Consultation Response from: KC Environmental Health (Pollution & Noise Control)
2024/93598 - Land east of, Crosland Road, Lindley, Huddersfield, HD3 3SU
Discharge of condition 11 (validation report) on previous permission 2020/90442 for variation condition 2 (plans) on previous permission 2016/92055 for erection of 109 dwellings with associated works
**Date Responded:
11th February 2025**
**Responding Officer:
NH**
**Responding Ref:
WK/202502504**
Condition 11 – Validation Report

Recommendations
Condition 11 – Validation Report

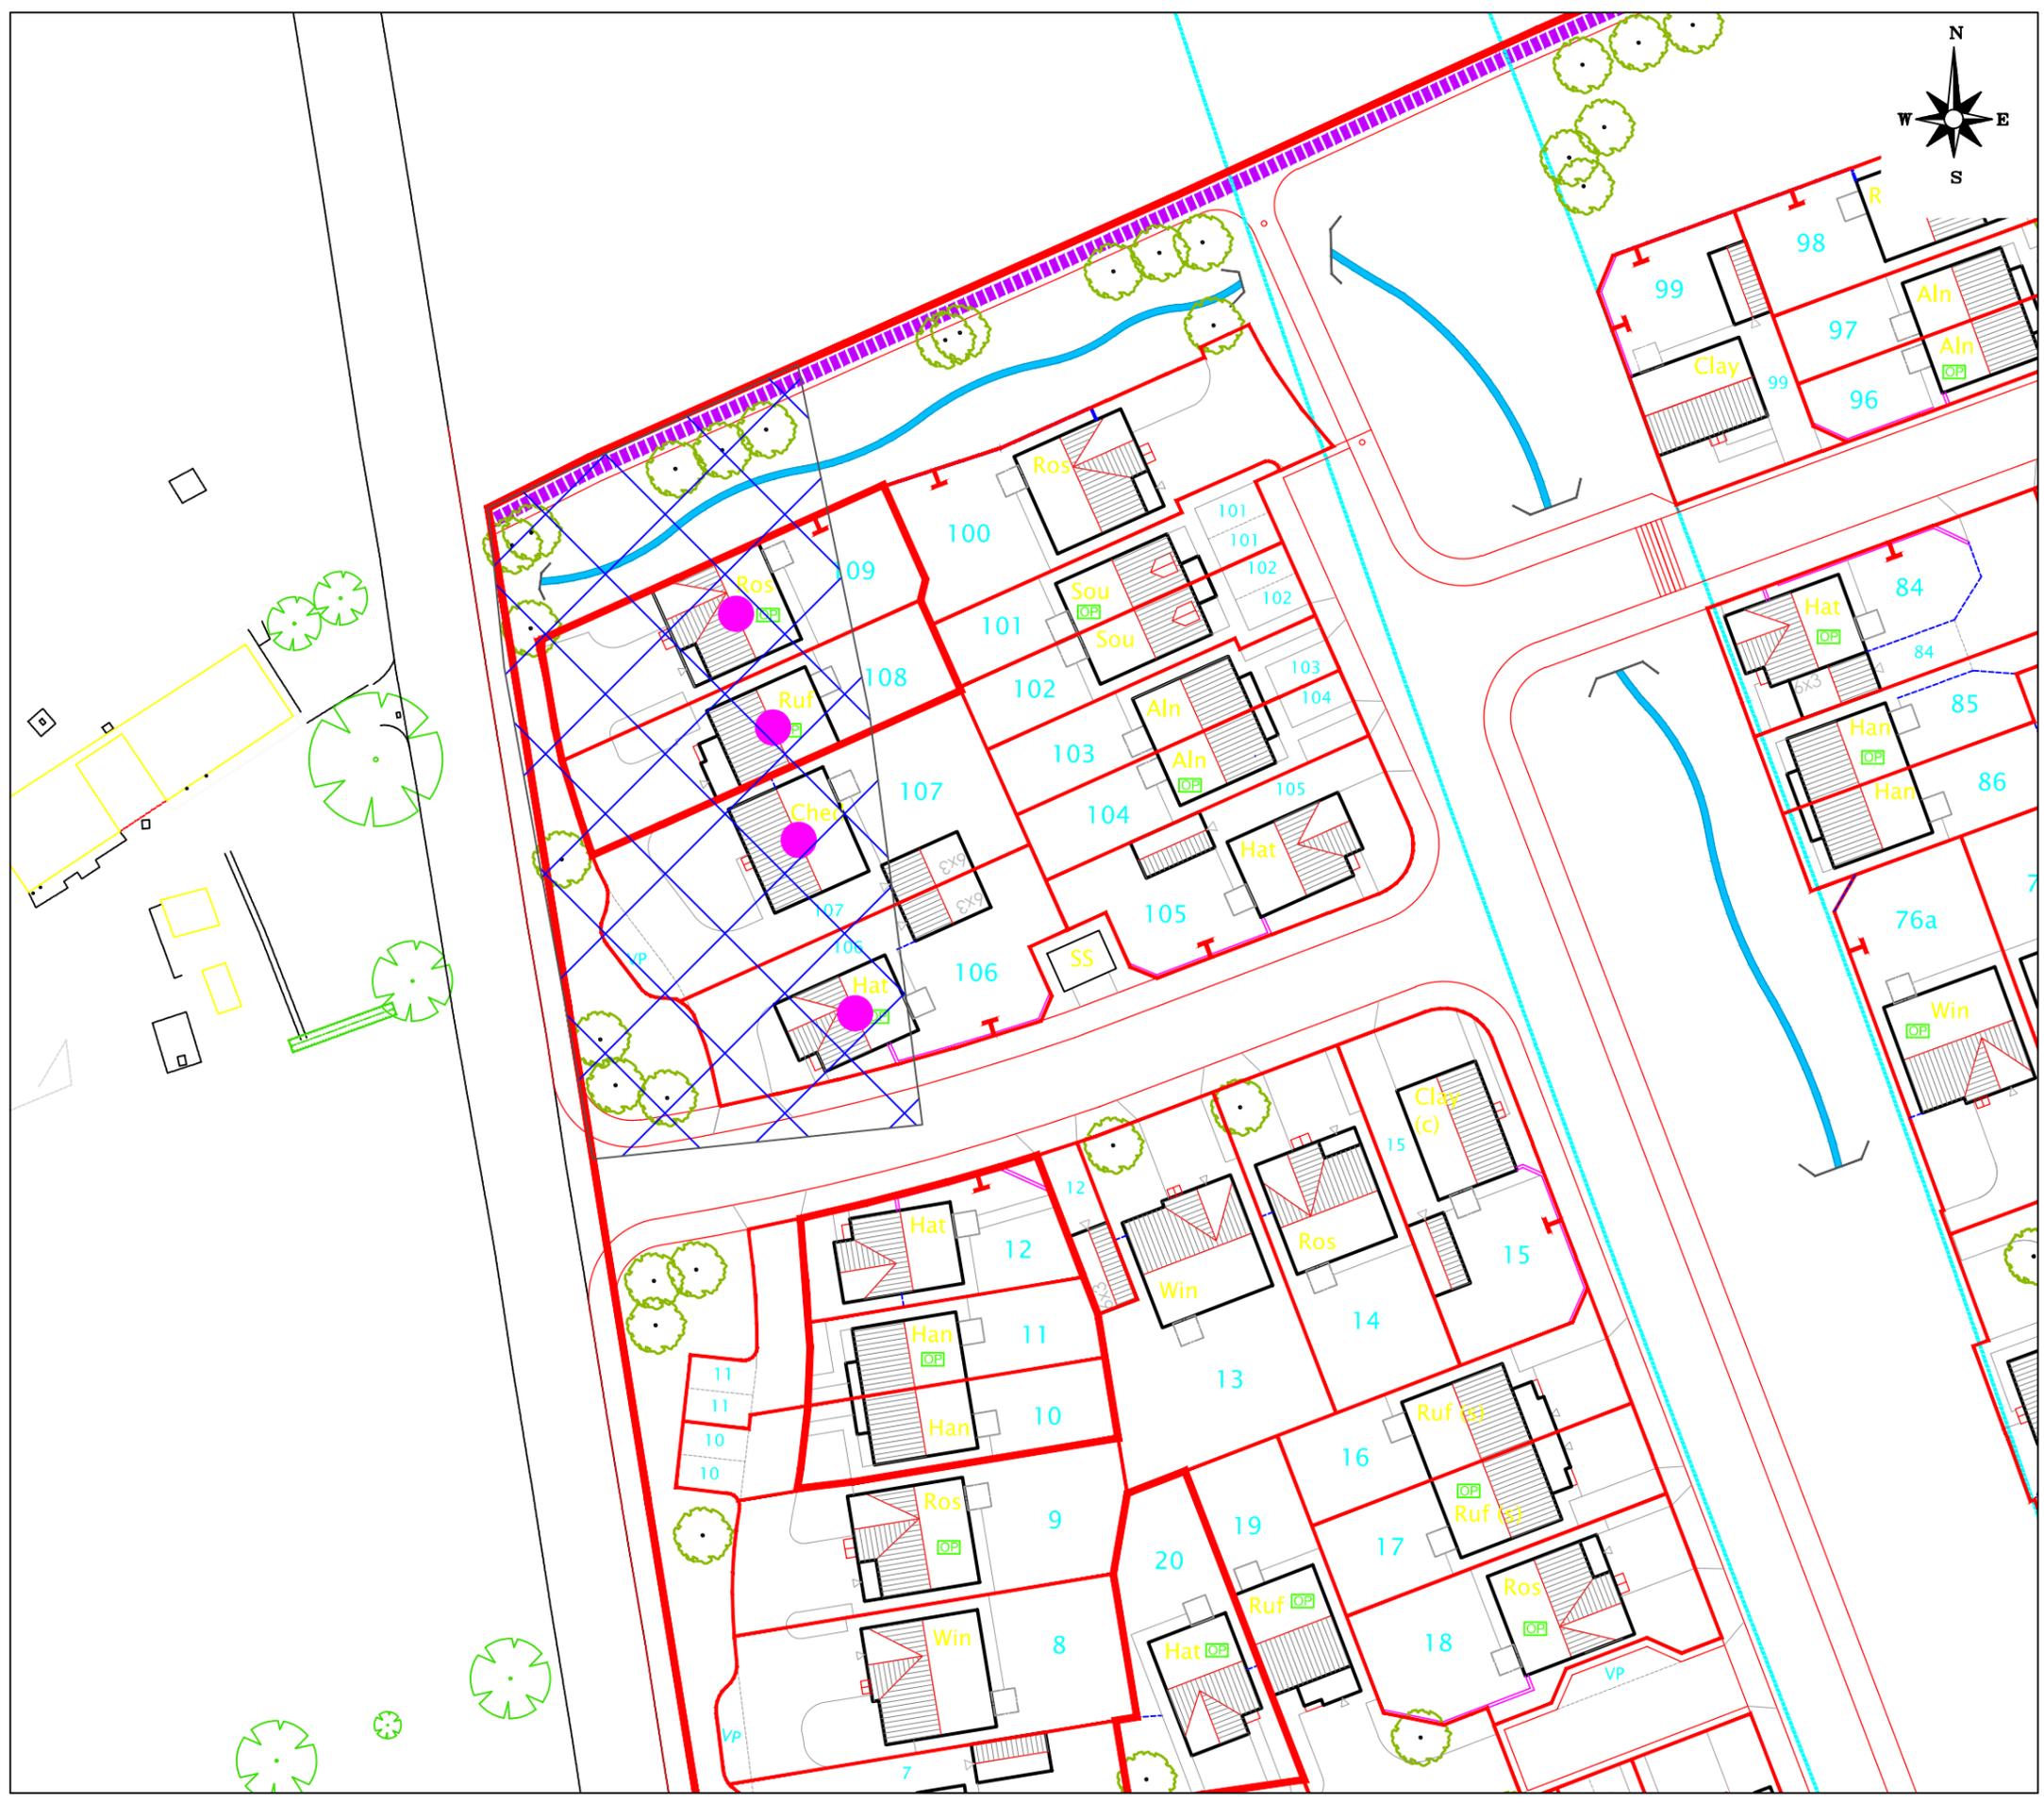
These are accepted and meets the verification proposal of the first 10 plots and subsequently every 5th plot. However, there is insufficient information in relation to the clean cover remediation agreed as part of this permission. For these reasons, Condition 11 must remain until further notice.

We accept the information received in support of the application to discharge Condition 11. However, additional information is required to satisfy the requirements of Condition 11 as this covers the remediation measures for the whole site.
